Your Ref: 100646500-001  
Our Ref: 23/02911/FULL

Date 13th November 2023

**Application No:** 23/02911/FULL  
**Proposal:** Alterations and extension to existing medical practice including erection of bin storage facilities and associated landscaping and drainage works  
**Address:** The Cannons Surgery Ajax Way Methil Leven Fife

Project: Airle Medical Centre Methil	
Description: Sections as Proposed	
Job No. 222069	Revision P1
Drawing No. 222069-ASL-XX-DR-A-0122

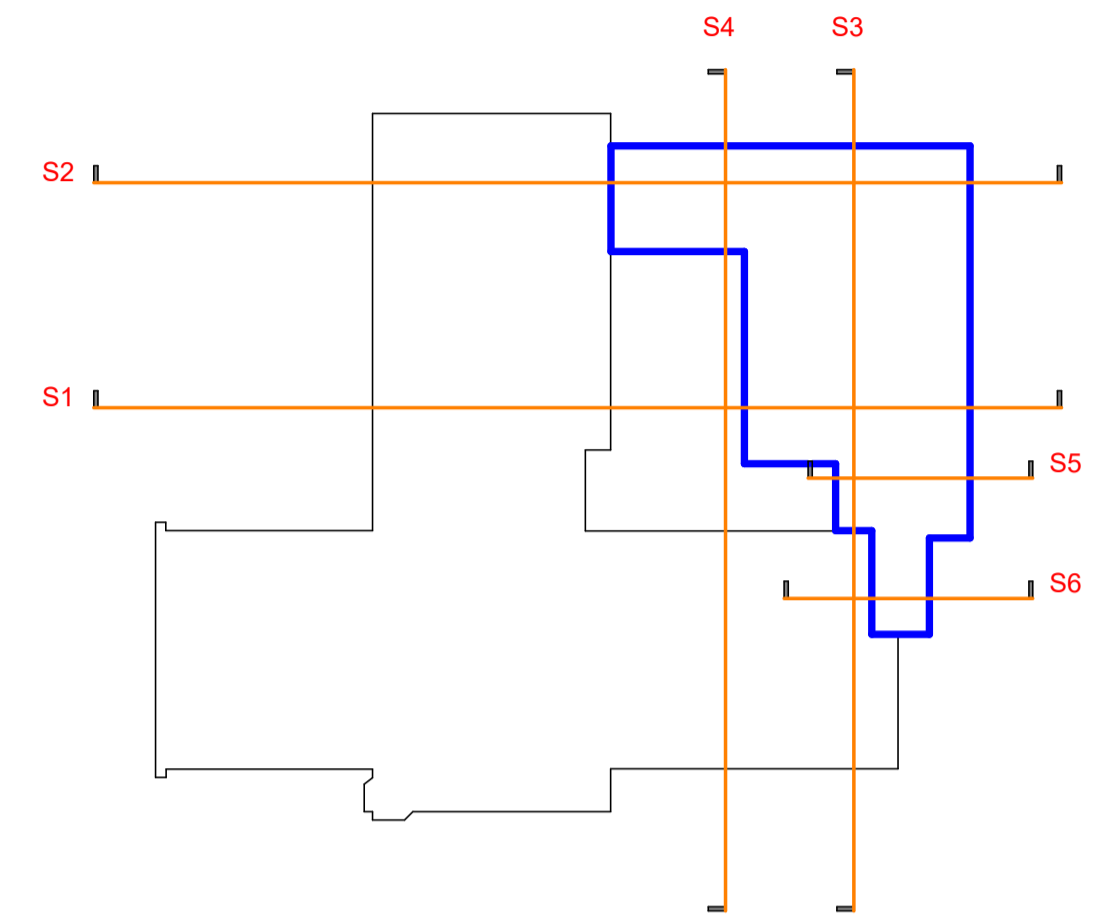
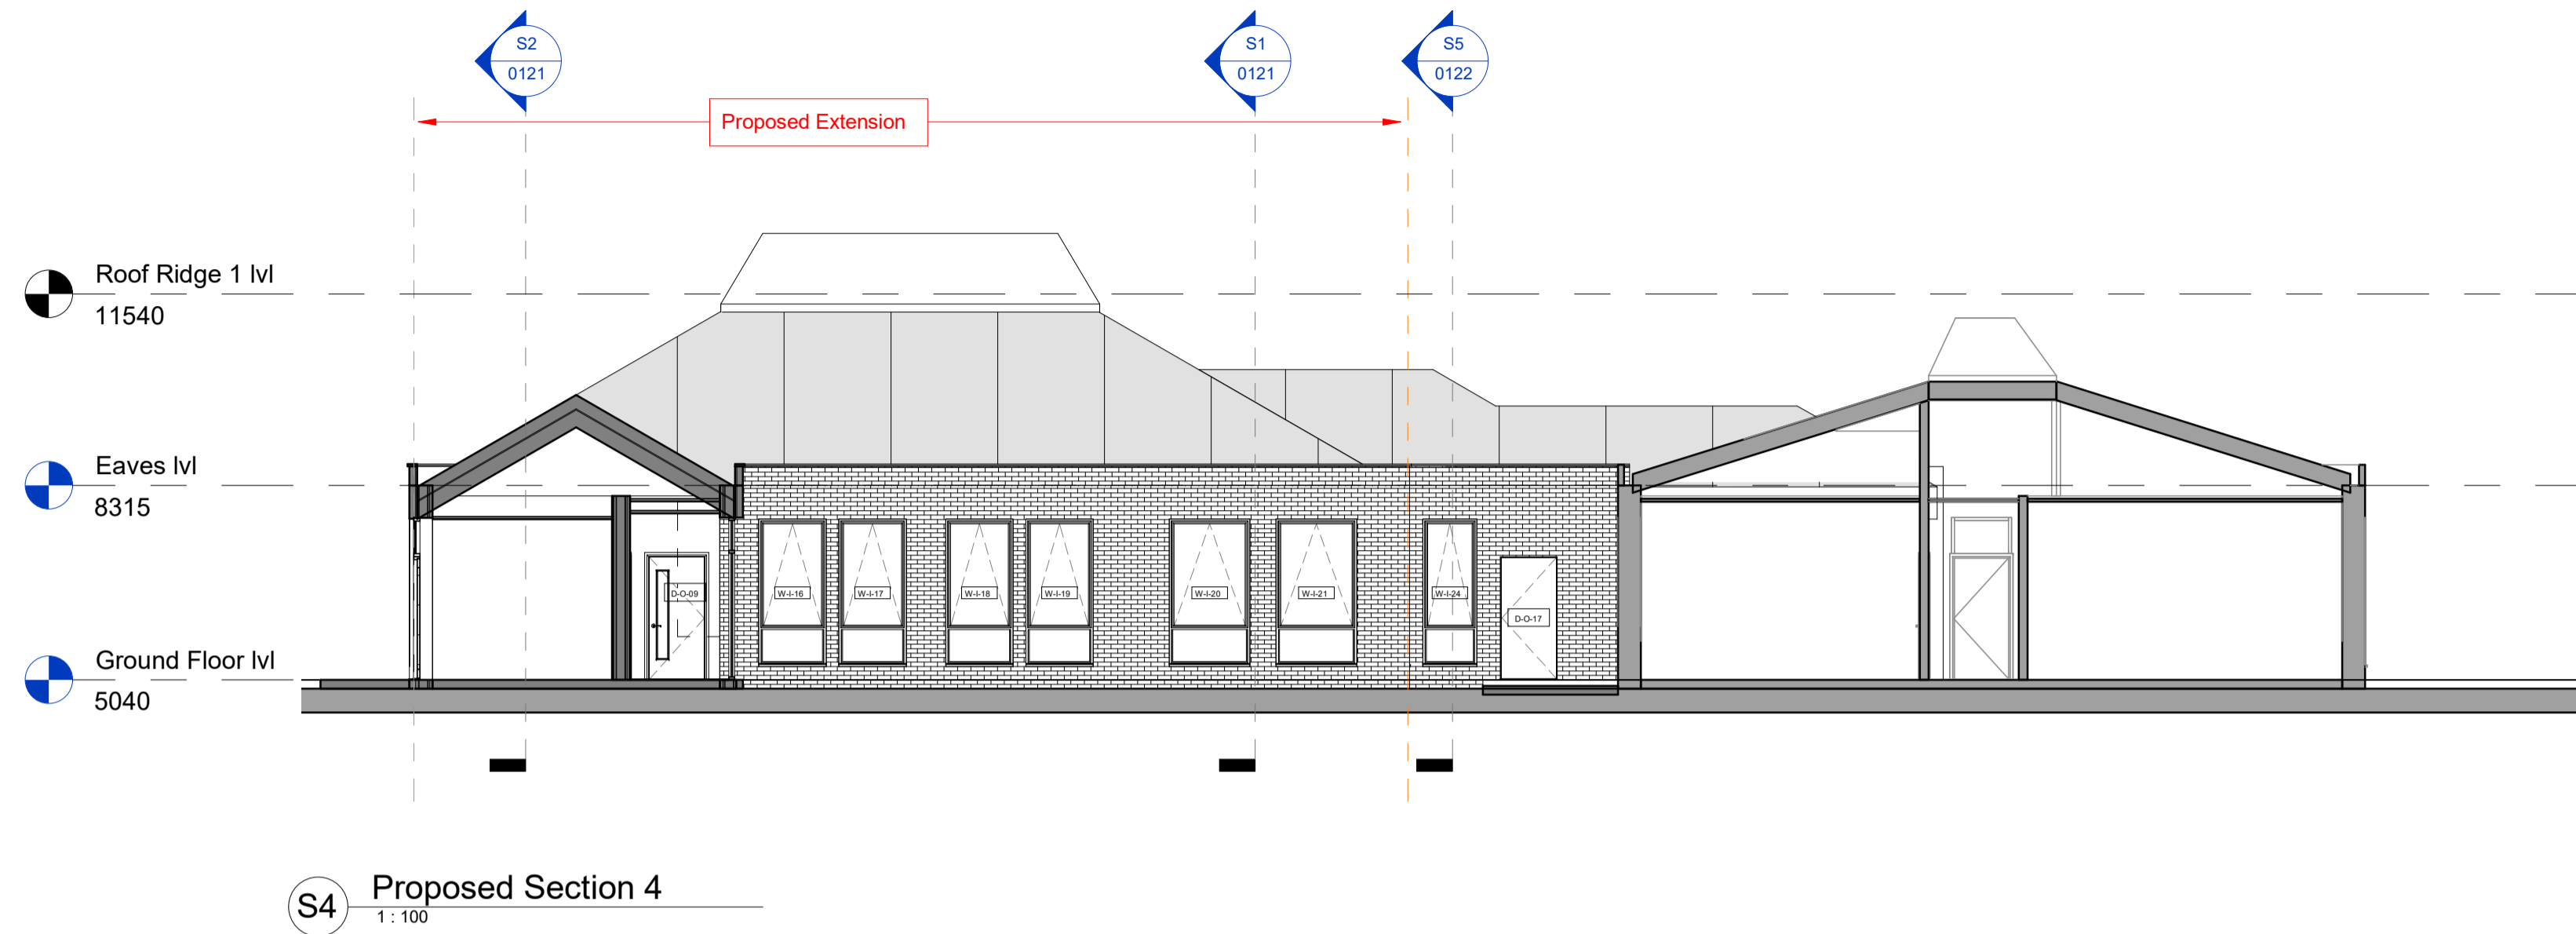
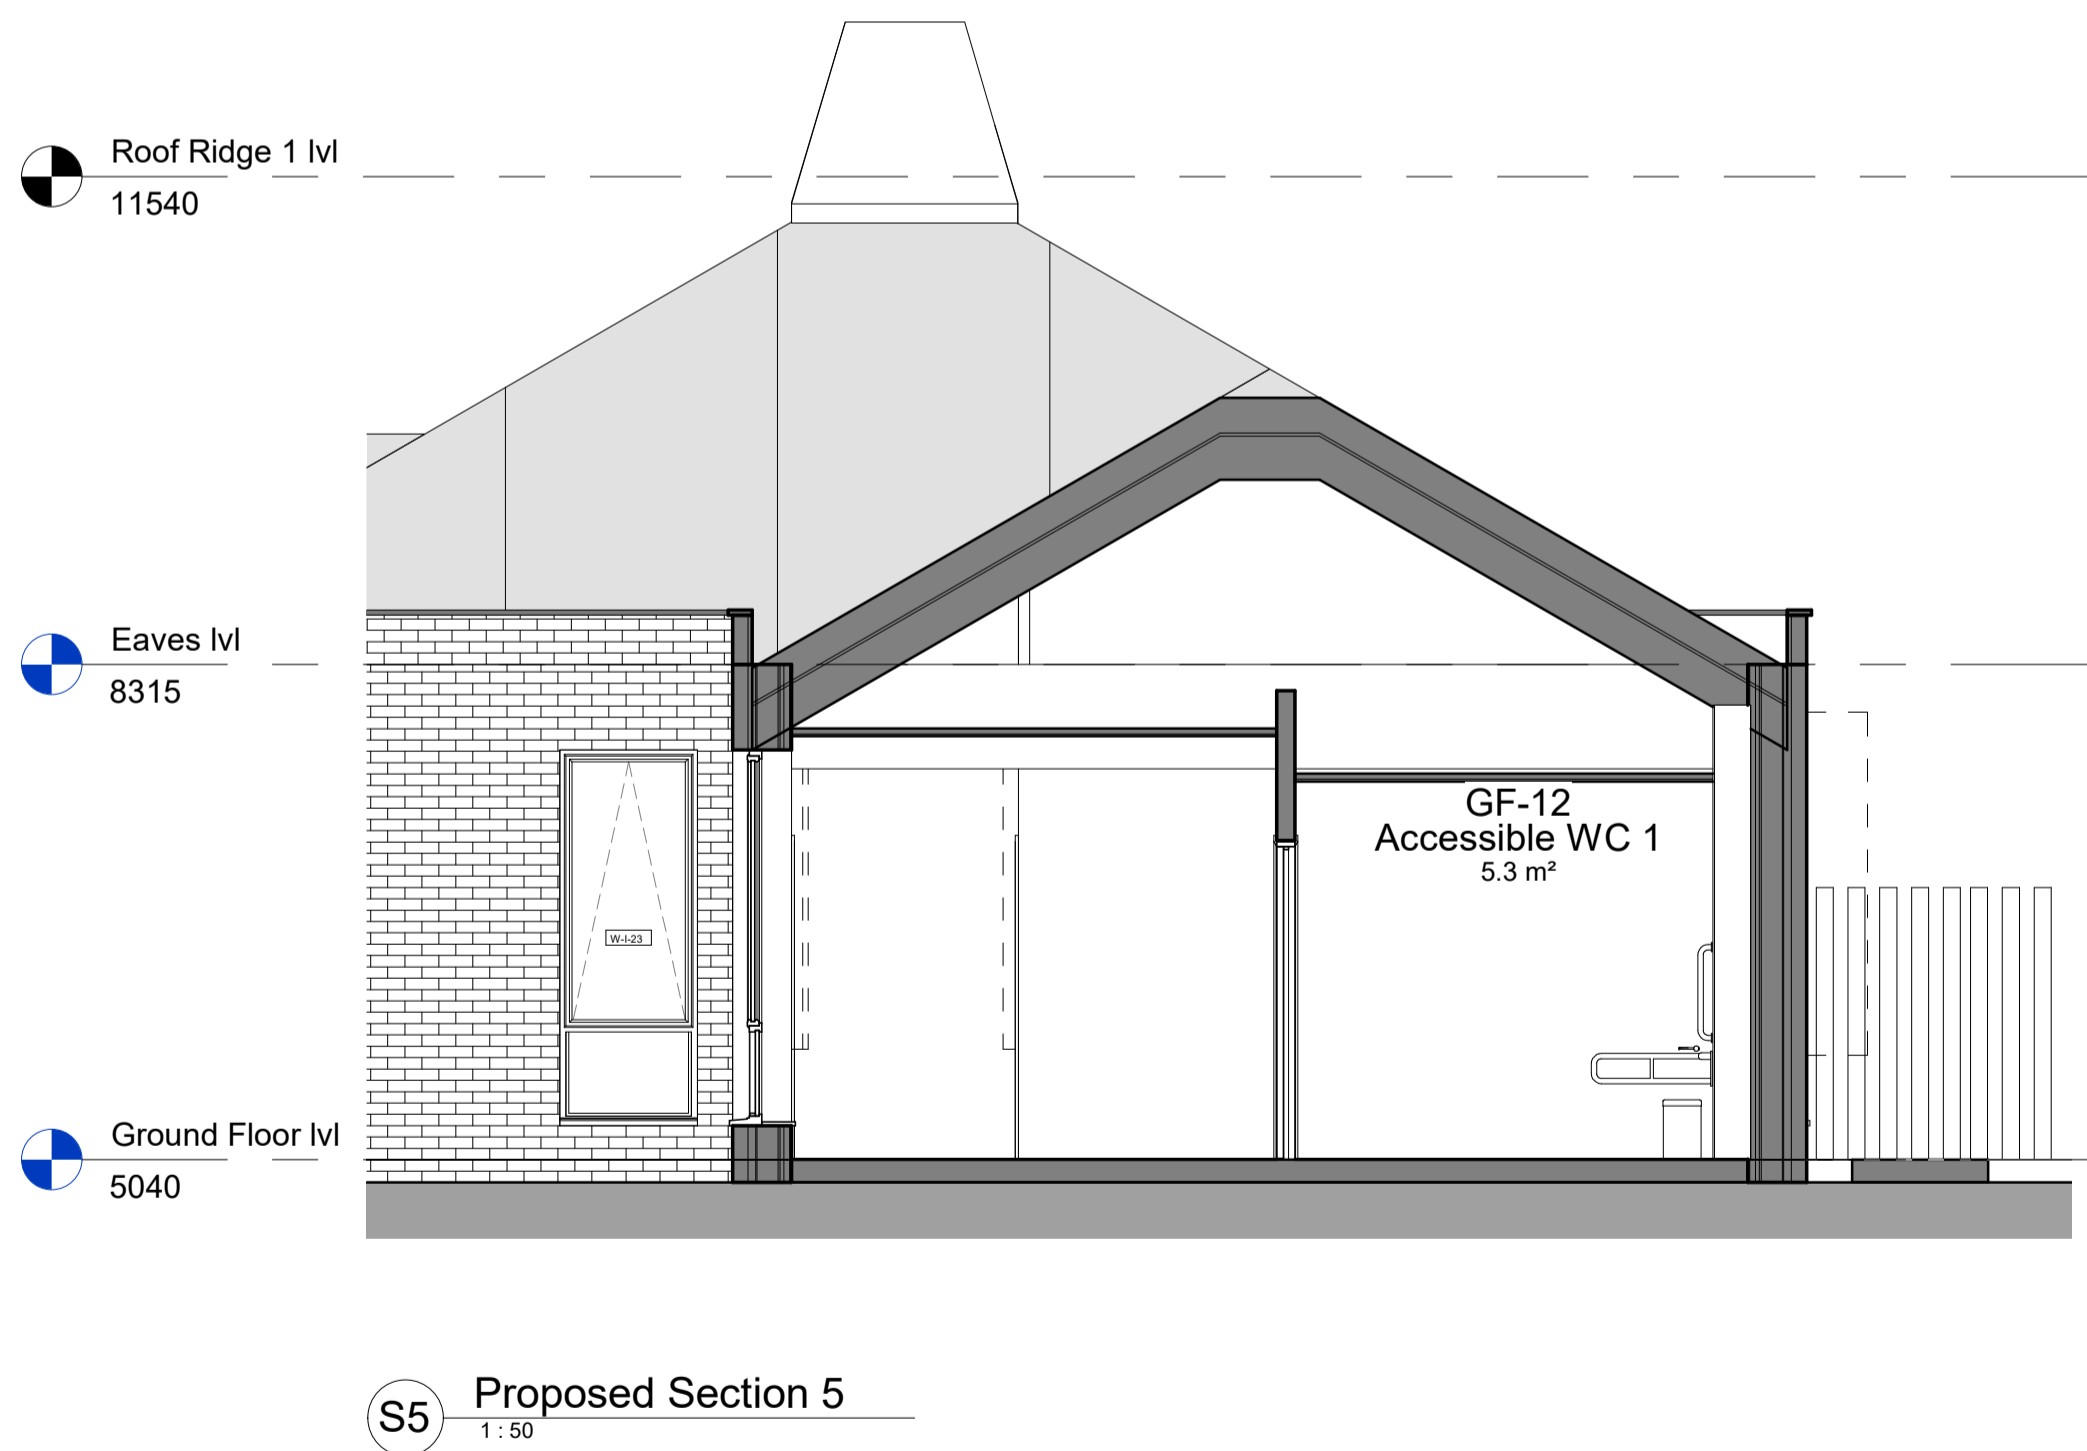
3. The scale to drawing no. 222069-ASL-XX-00-DR-A-0121/122 (Proposed Sections) does not match the annotated scale in the title box. If this could be amended to show the correct scale to allow measurement and calibration of the plans.
